Awel y Môr Offshore Wind Farm Limited

**Date: 18/10/2022**  
**Our Ref: PLA0068057**  
**Your Ref: EN010112**

**Site: Awel y Môr Offshore Wind Farm project, Denbighshire**

**Development: Order Granting Development Consent for the Awel y Môr Offshore Wind Farm project**

Map Ref: 303548,382436
Map scale: 1:1250
Printed by: Lester Barrow
Printed on: 18 Oct 2022

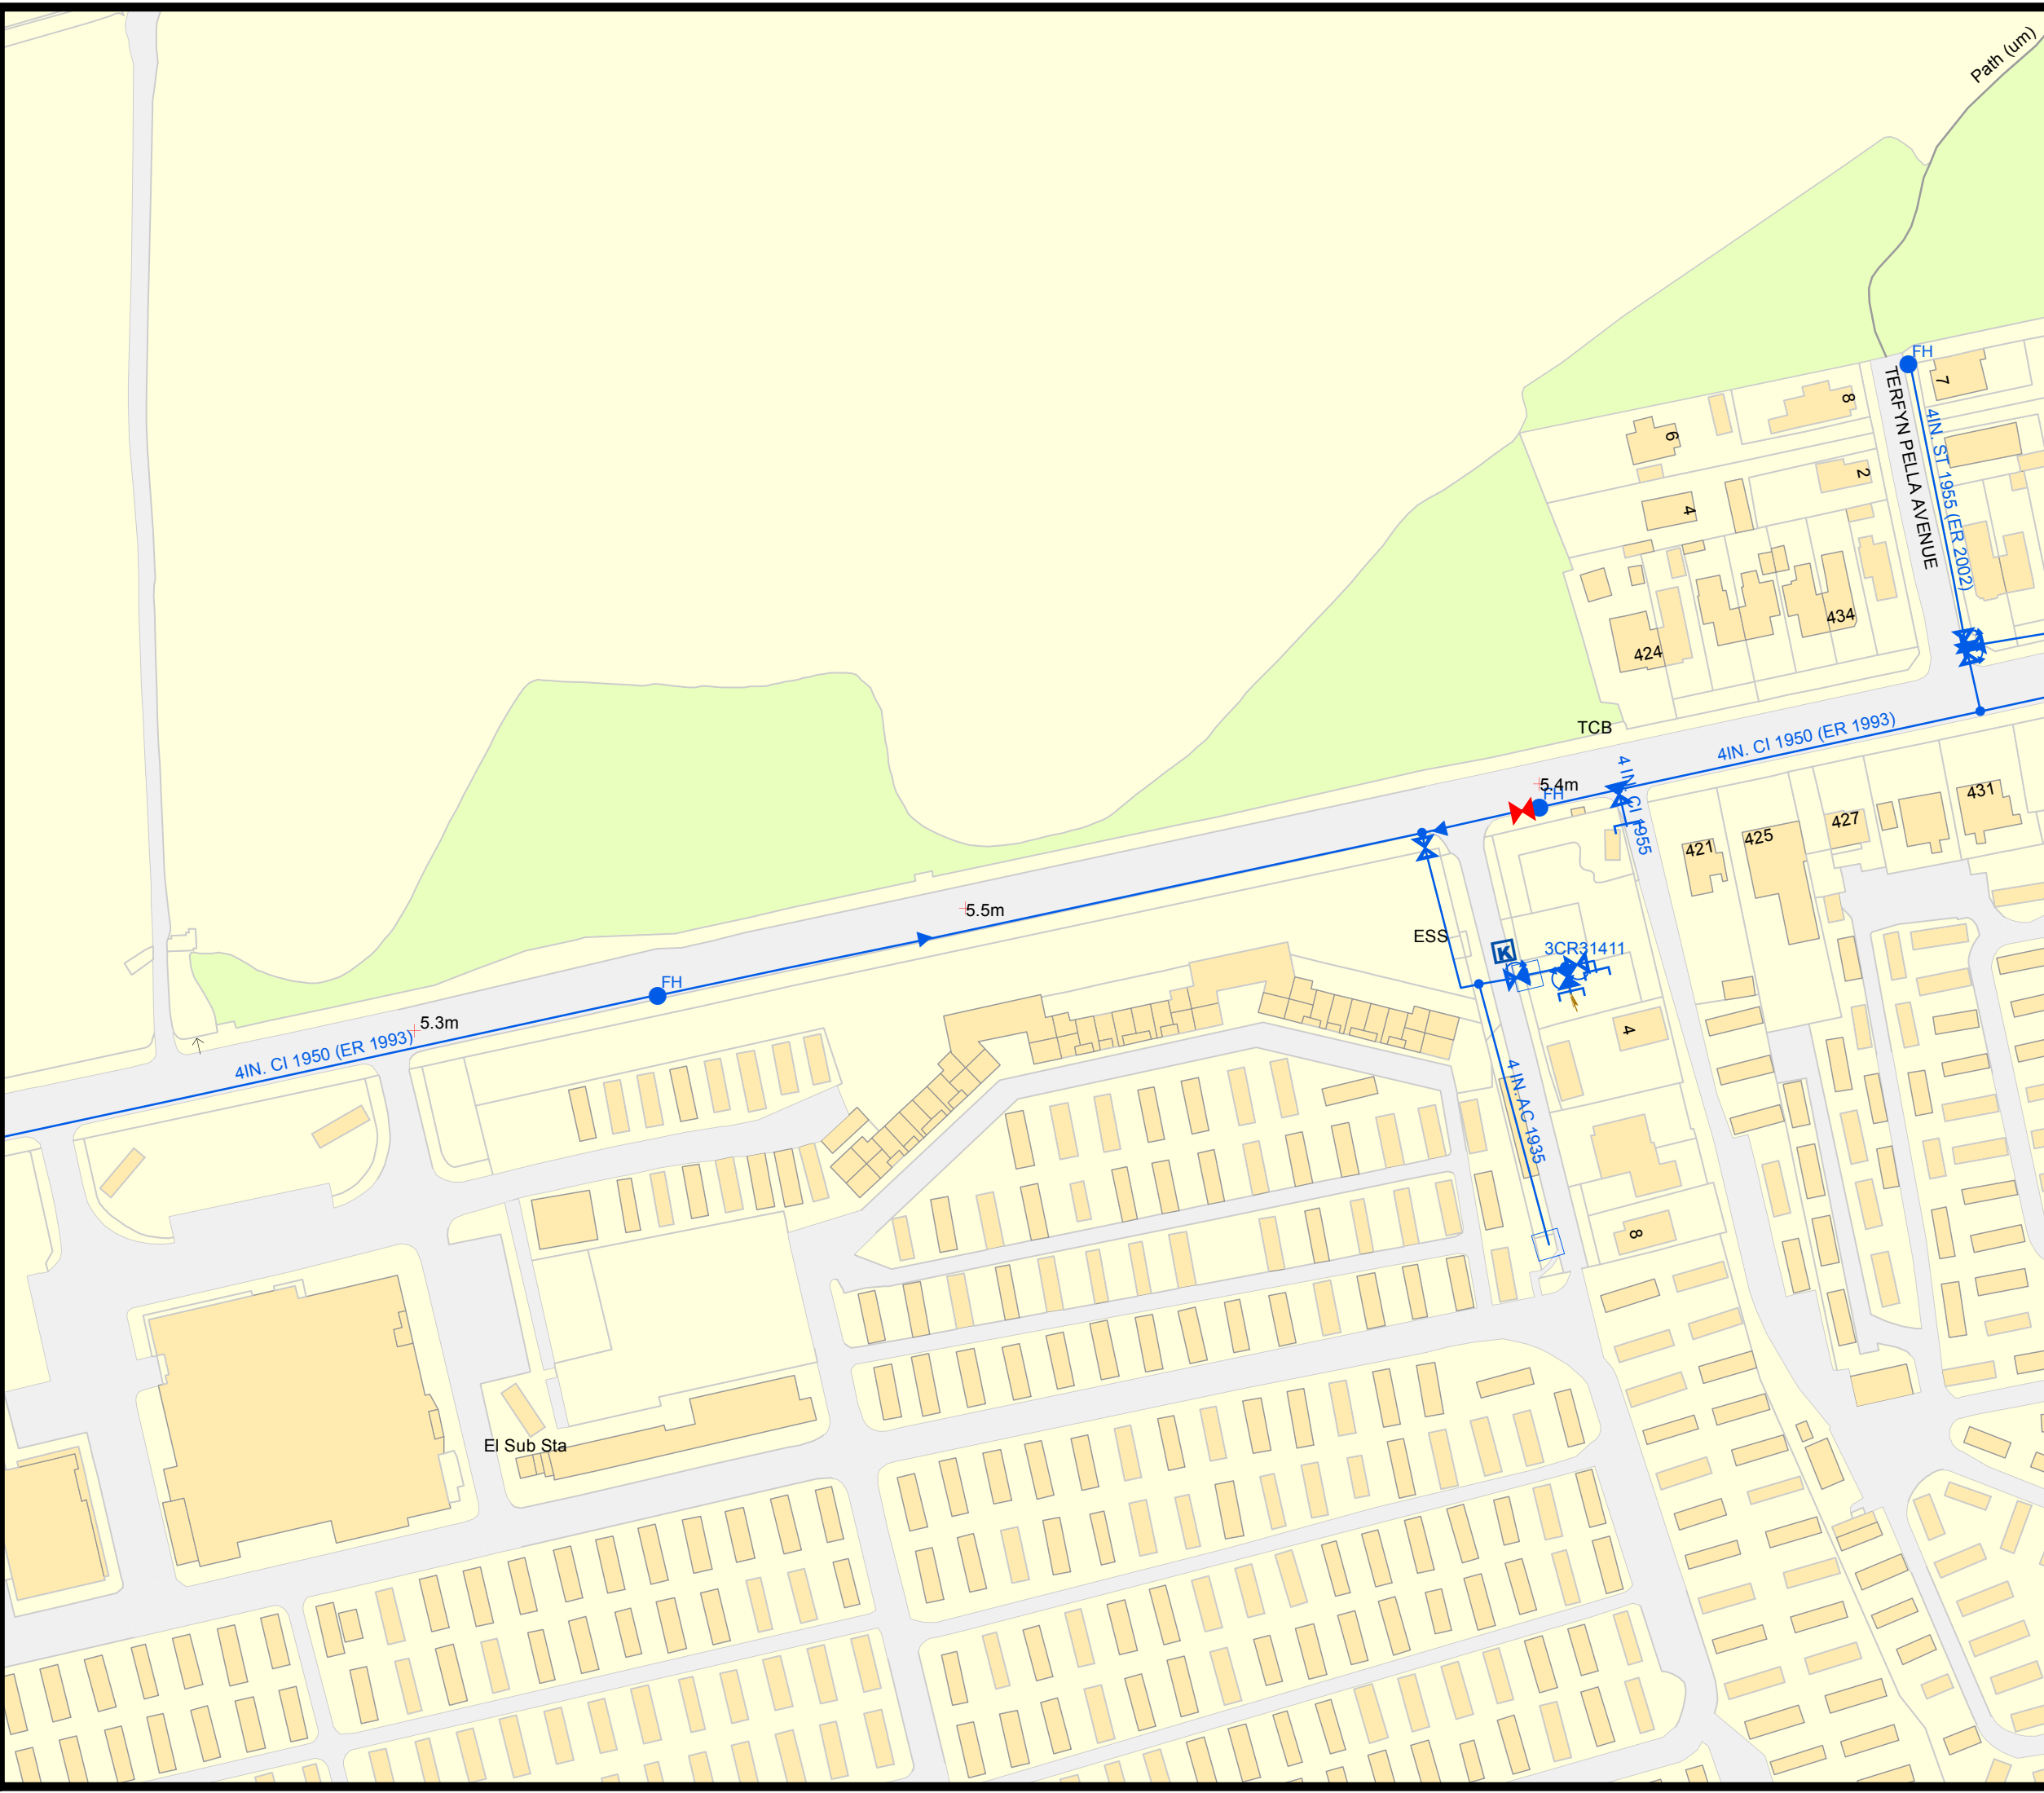
No part of any building will be permitted within 3 metres either side of the centreline of the 4" public watermain (grid reference: 303547.61, 382435.29) - water plan 1

Map Ref: 302190,378834
Map scale: 1:1250
Printed by: Lester Barrow
Printed on: 18 Oct 2022

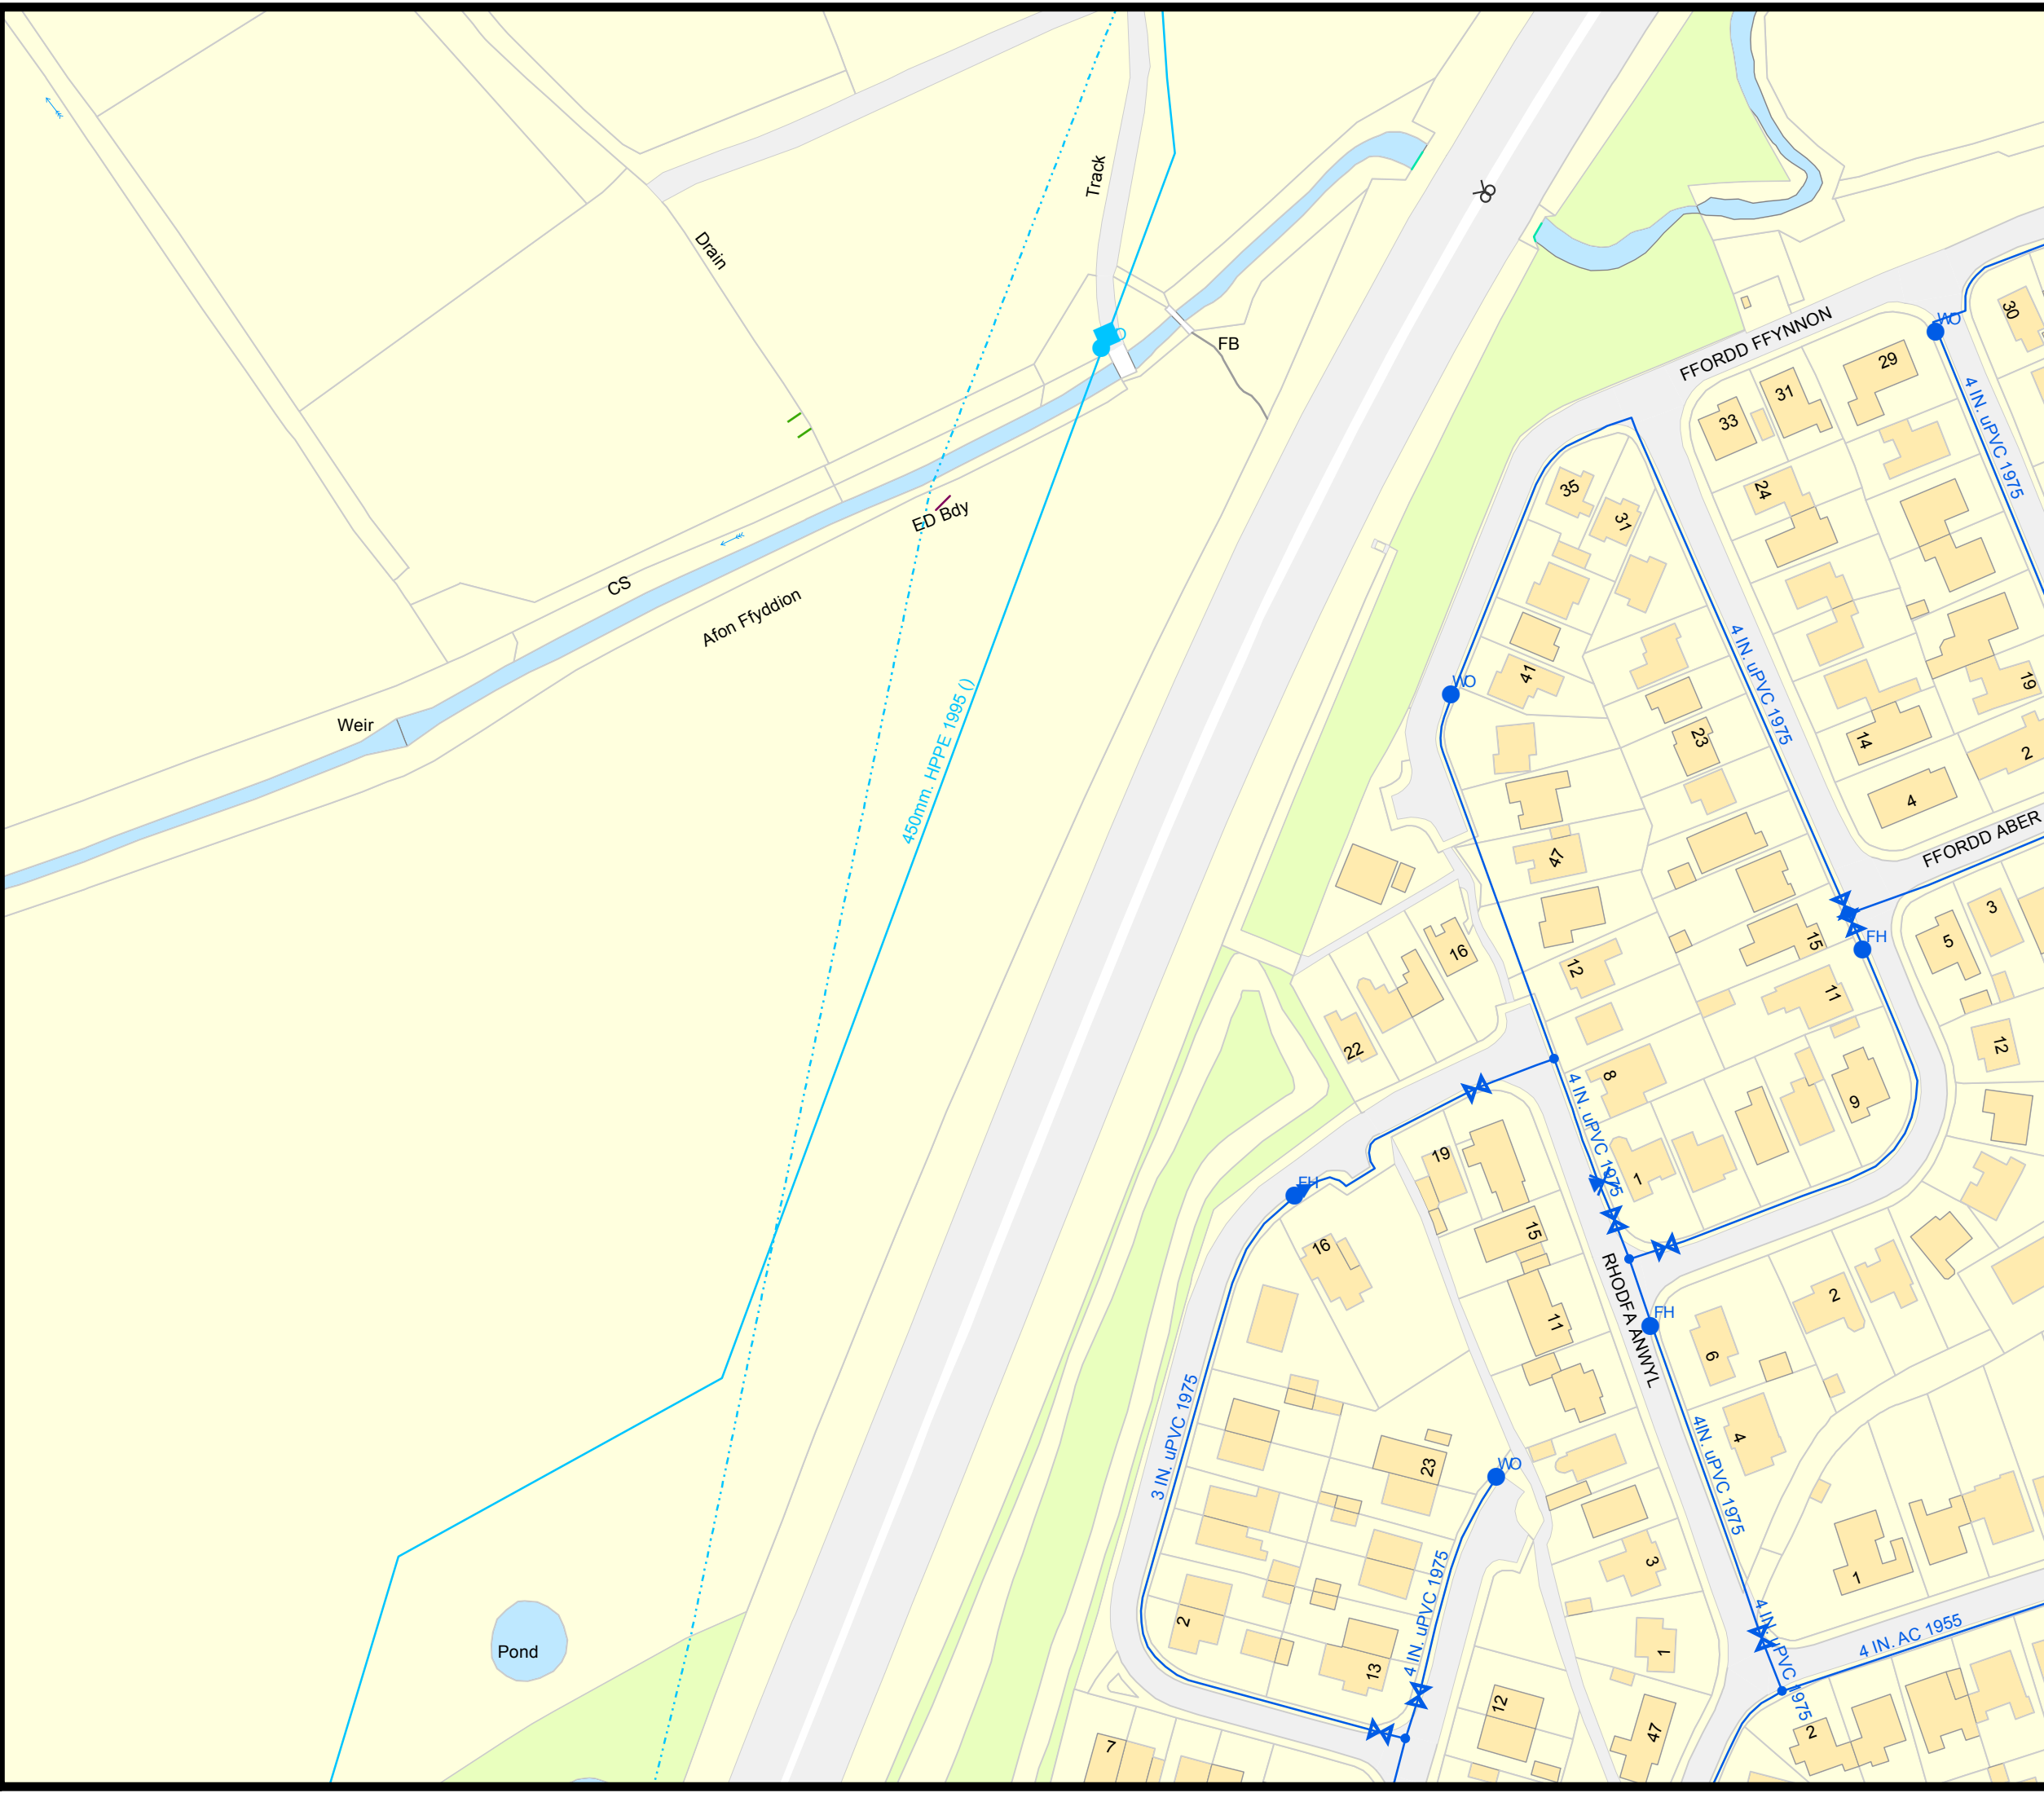
No part of any building will be permitted within 4.5 metres either side of the centreline of the 300mm public watermain (grid reference: 302208.79, 378853.53) - water plan 3

No part of any building will be permitted within 4.5 metres either side of the centreline of the 450mm public watermain (grid reference: 302169.68, 378846.37) - water plan 3

No part of any building will be permitted within 4.5 metres either side of the centreline of the 15" public abandoned watermain (grid reference: 302169.68, 378846.37) - water plan 3

No part of any building will be permitted within 5.5 metres either side of the centreline of the 525mm public surface water sewer (grid reference: 302199.62, 378860.90) - water plan 3

Map Ref: 304487,382744
Map scale: 1:1250
Printed by: Lester Barrow
Printed on: 18 Oct 2022

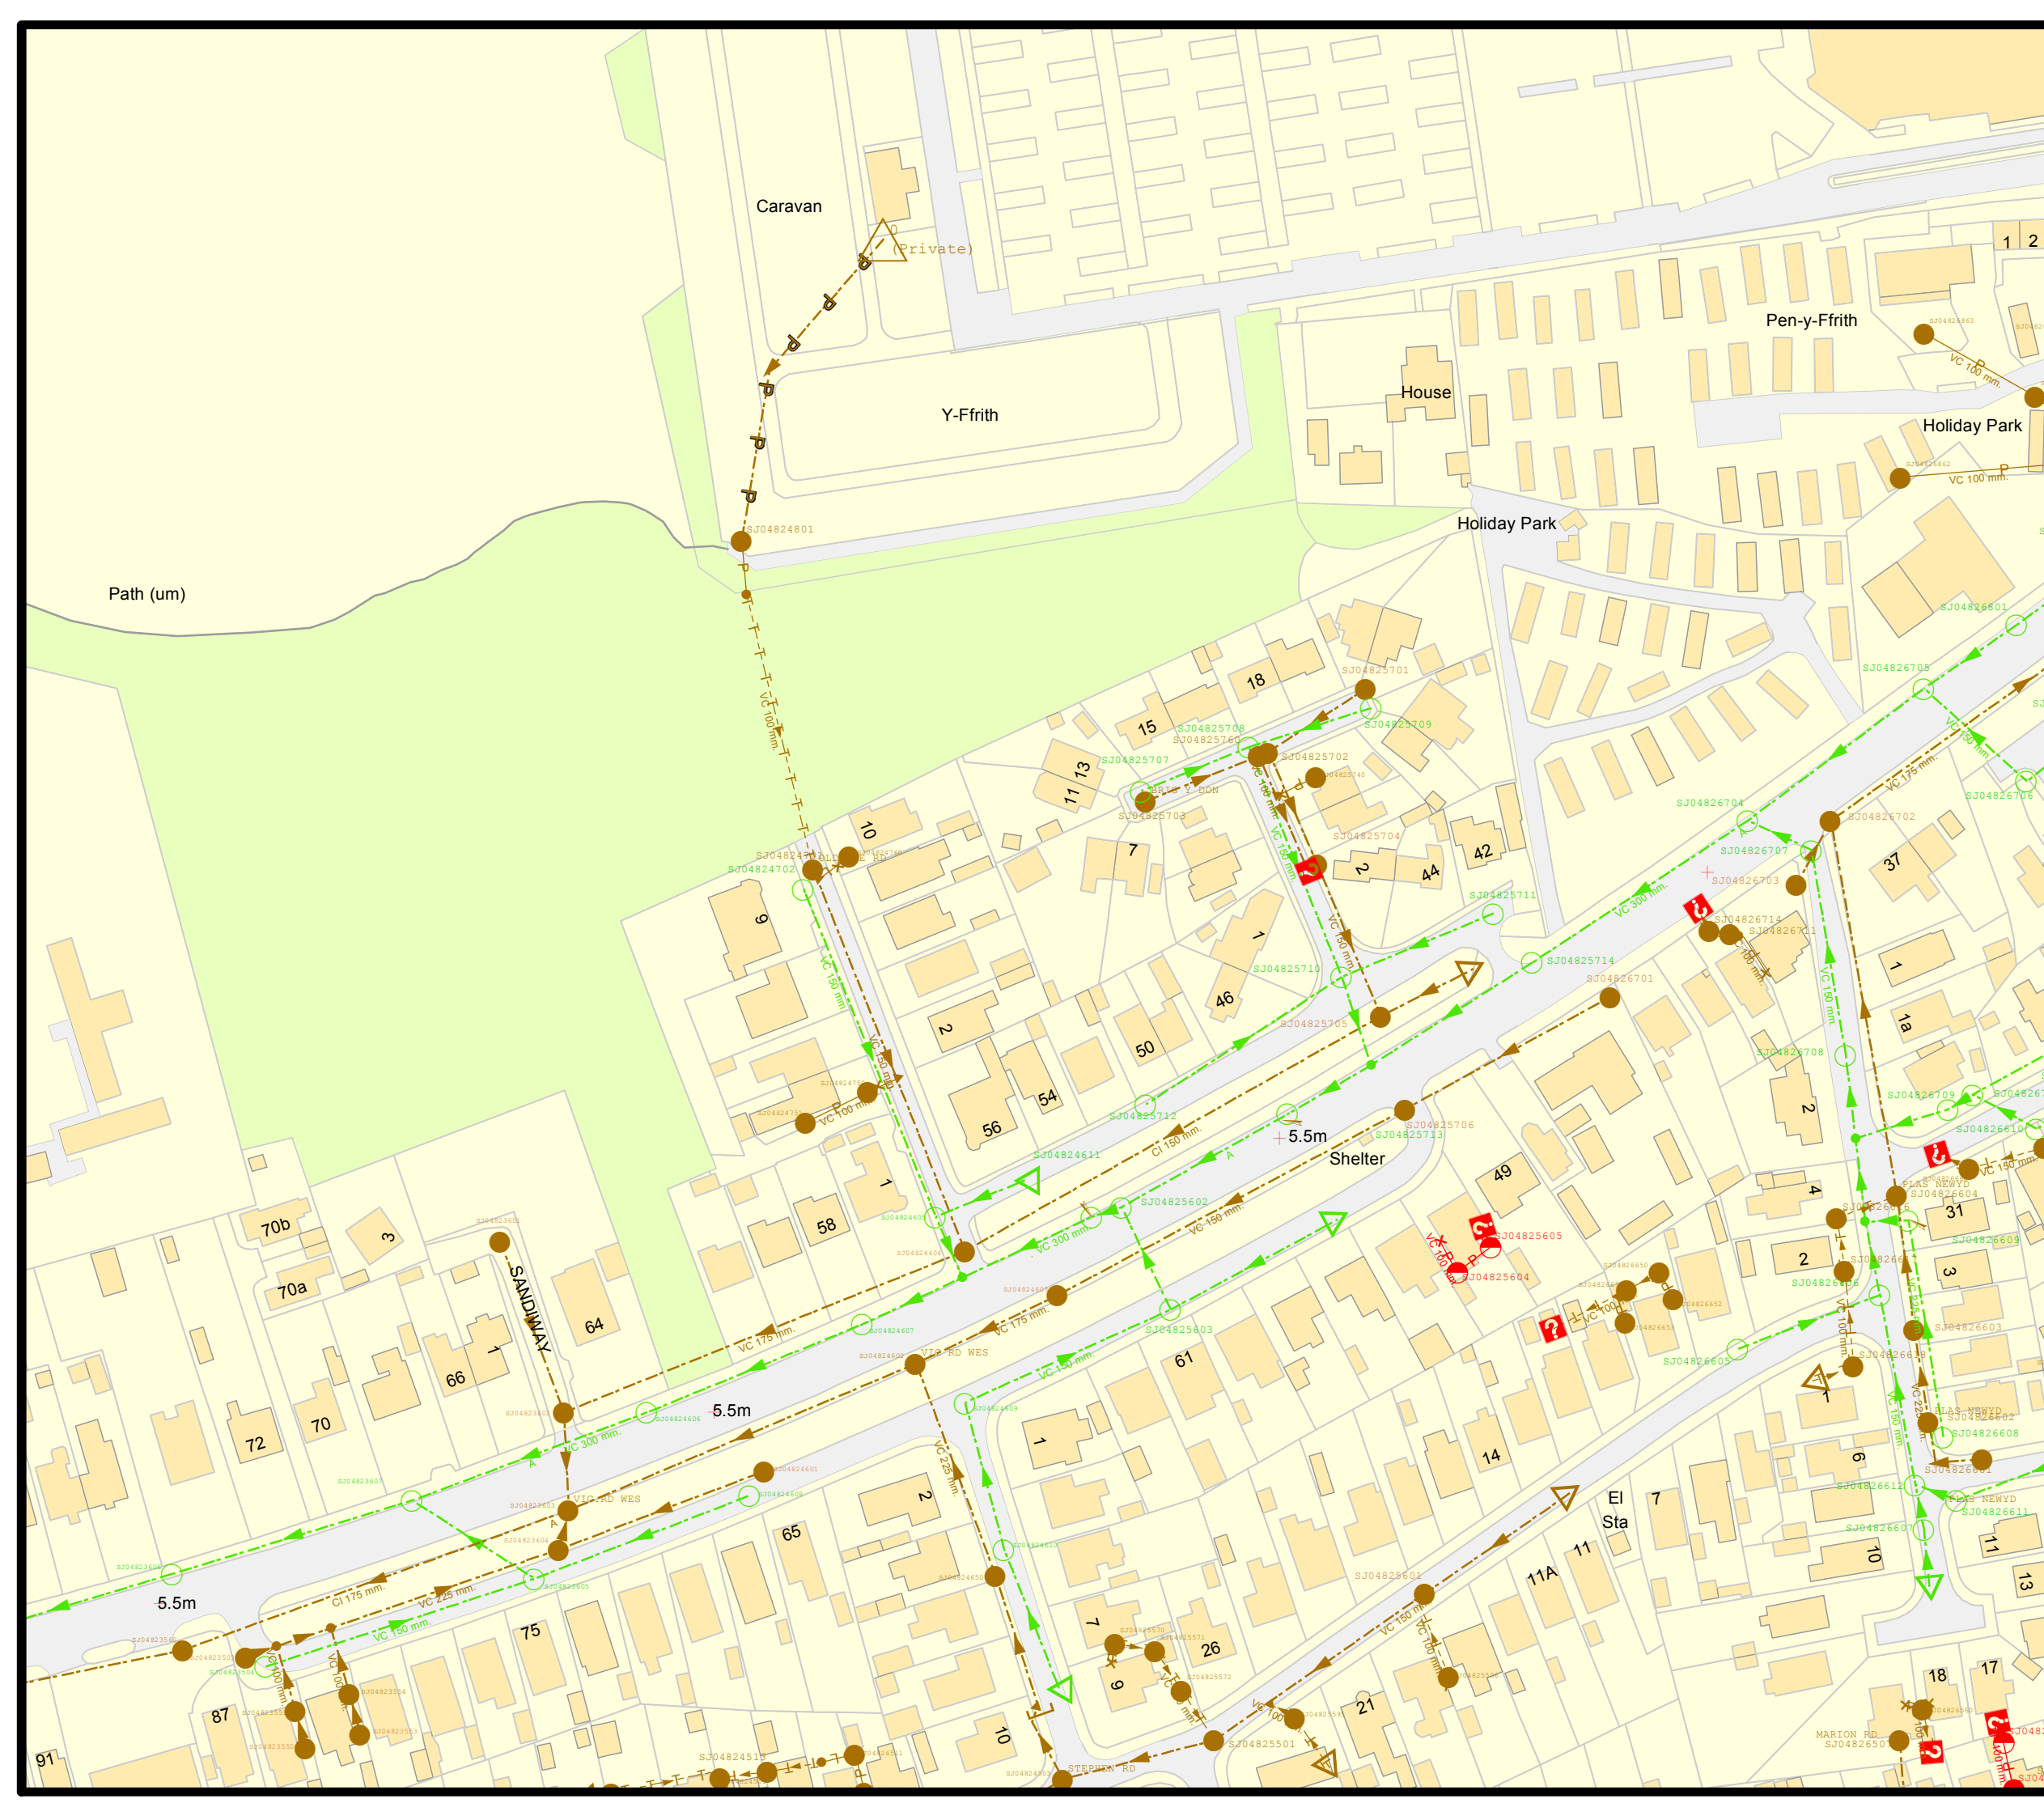
No part of any building will be permitted within 3 metres either side of the centreline of the 100mm public foul sewer (grid reference: 304432.01, 382785.76) - sewer plan 1
